**EXHIBITION OF REVISED PREFERRED PROJECT REPORT FOR THE PROPOSED
WARNER INDUSTRIAL PARK**

Reference is made to the above application providing the Department of Environment, Climate Change and Water (DECCW) an opportunity to make a written submission on the proposal. Reference is also made to the report entitled "Preferred Project Report – Warner Industrial Park Concept Plan and Project Application, Precinct 14 WEZ, Sparks Rd and Hue Hue Rd, Warnervale (Revision A – May 2009)".

Attachment 1 – Comments on Preferred Project Report (Revision A – May 2009)

CONCEPT PLAN

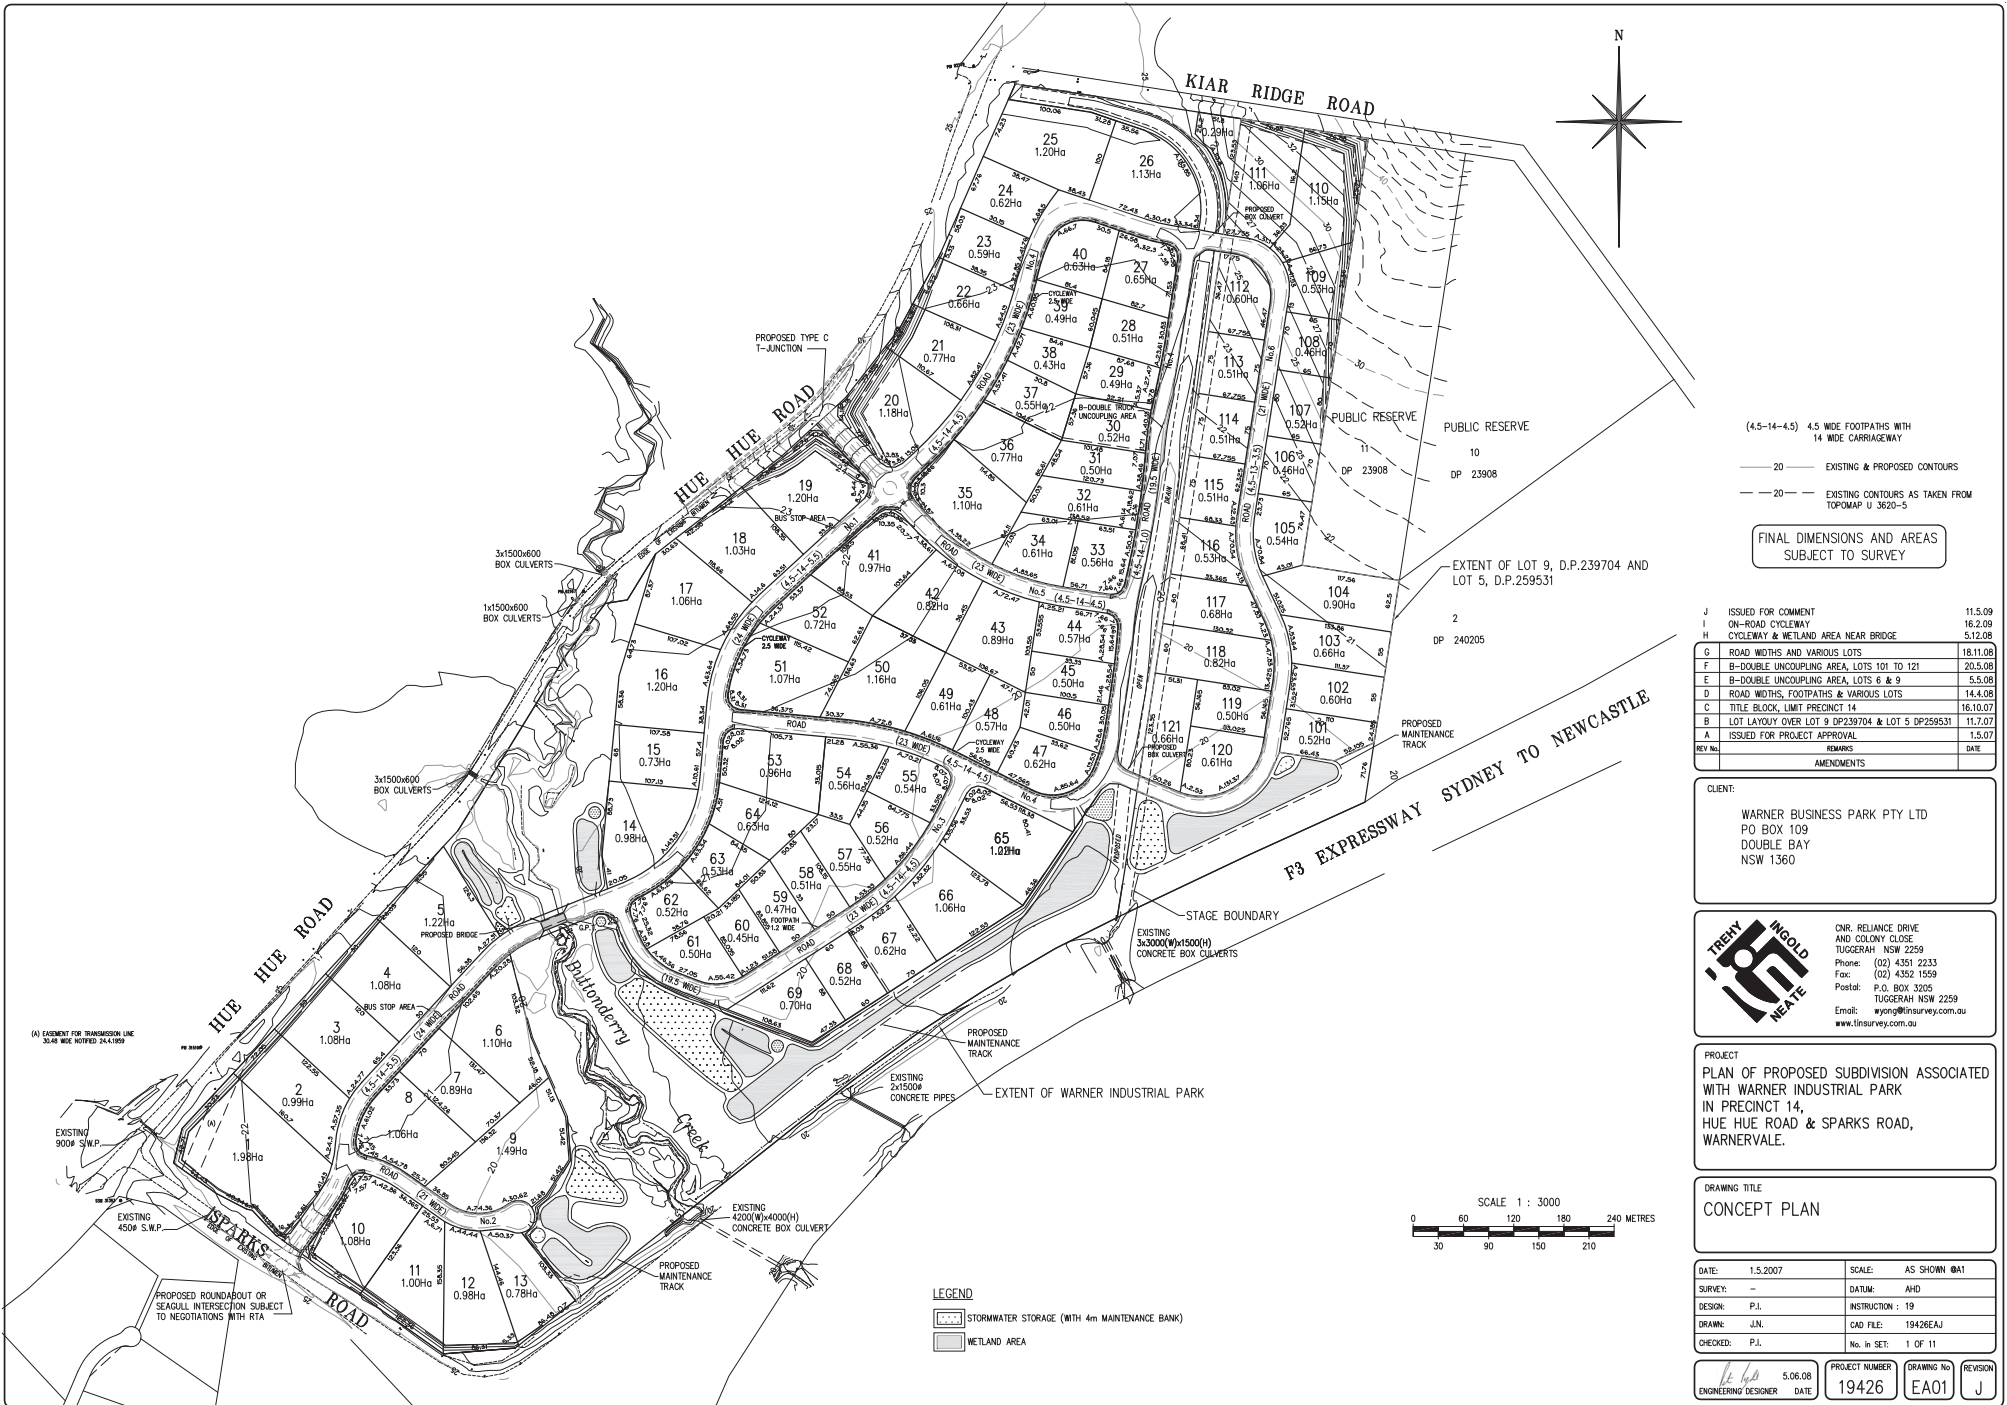
This proposal however compromises the ability of the WEZ to achieve a 'maintain or improve' outcome as the area assessed for BioCertification is now being heavily impacted upon by stormwater storage as well as other infrastructure as detailed in the Concept Plan and associated engineering drawings provided in Appendix 1 to the Preferred Project Report (Revision A – May 2009). Infrastructure within these areas includes large stormwater basins, a 4m proposed maintenance track around the stormwater detention basins, proposed sewer mains and rising mains as well as Telstra cables. This infrastructure will reduce the size of the area available for conservation, will require ongoing maintenance, may require additional clearing and increase fragmentation of important habitat, all of which will inhibit the capacity of these areas to contribute to the biodiversity and habitat values of the conservation zoned lands.

It is estimated that the construction of the stormwater detention basins alone would reduce the conservation area by approximately 20%. The width of the vegetated corridor adjacent to the F3 Freeway and along Buttonderry Creek is also significantly reduced to accommodate this infrastructure.

It is further noted that there is a bridged crossing proposed across Buttonderry Creek and an associated roadway through the E2 zoned lands and mapped Endangered Ecological Community. Once again, whilst permissible with consent, DECCW strongly opposes the alignment of this road through the conservation lands due to fragmentation and environmental impacts on these lands.

In accordance with our previous correspondence, DECCW recommends that all infrastructure is relocated out of the E2 zone.

DECCW also notes the 'proposed open drain' alignment adjacent proposed lots 112 – 118 and 121, and advises that this area should be revegetated to reflect a natural watercourse feature of the site. This area has been zoned E2 Environmental Conservation and it should be treated as such. Landscaping within this area should be in accordance with the requirements of the Rural Fire Service (RFS) (i.e. landscaping in accordance with the principles of Appendix 5 of Planning for Bushfire Protection, 2006) and consist of native mesophyllic plant species which would not significantly contribute to fuel loadings and may retard fire activities in low intensity fires. This in turn may reduce the need for an asset protection zone provided to the above mentioned proposed lots; however the provision of an APZ would still need to be considered in accordance with the requirements of the RFS.
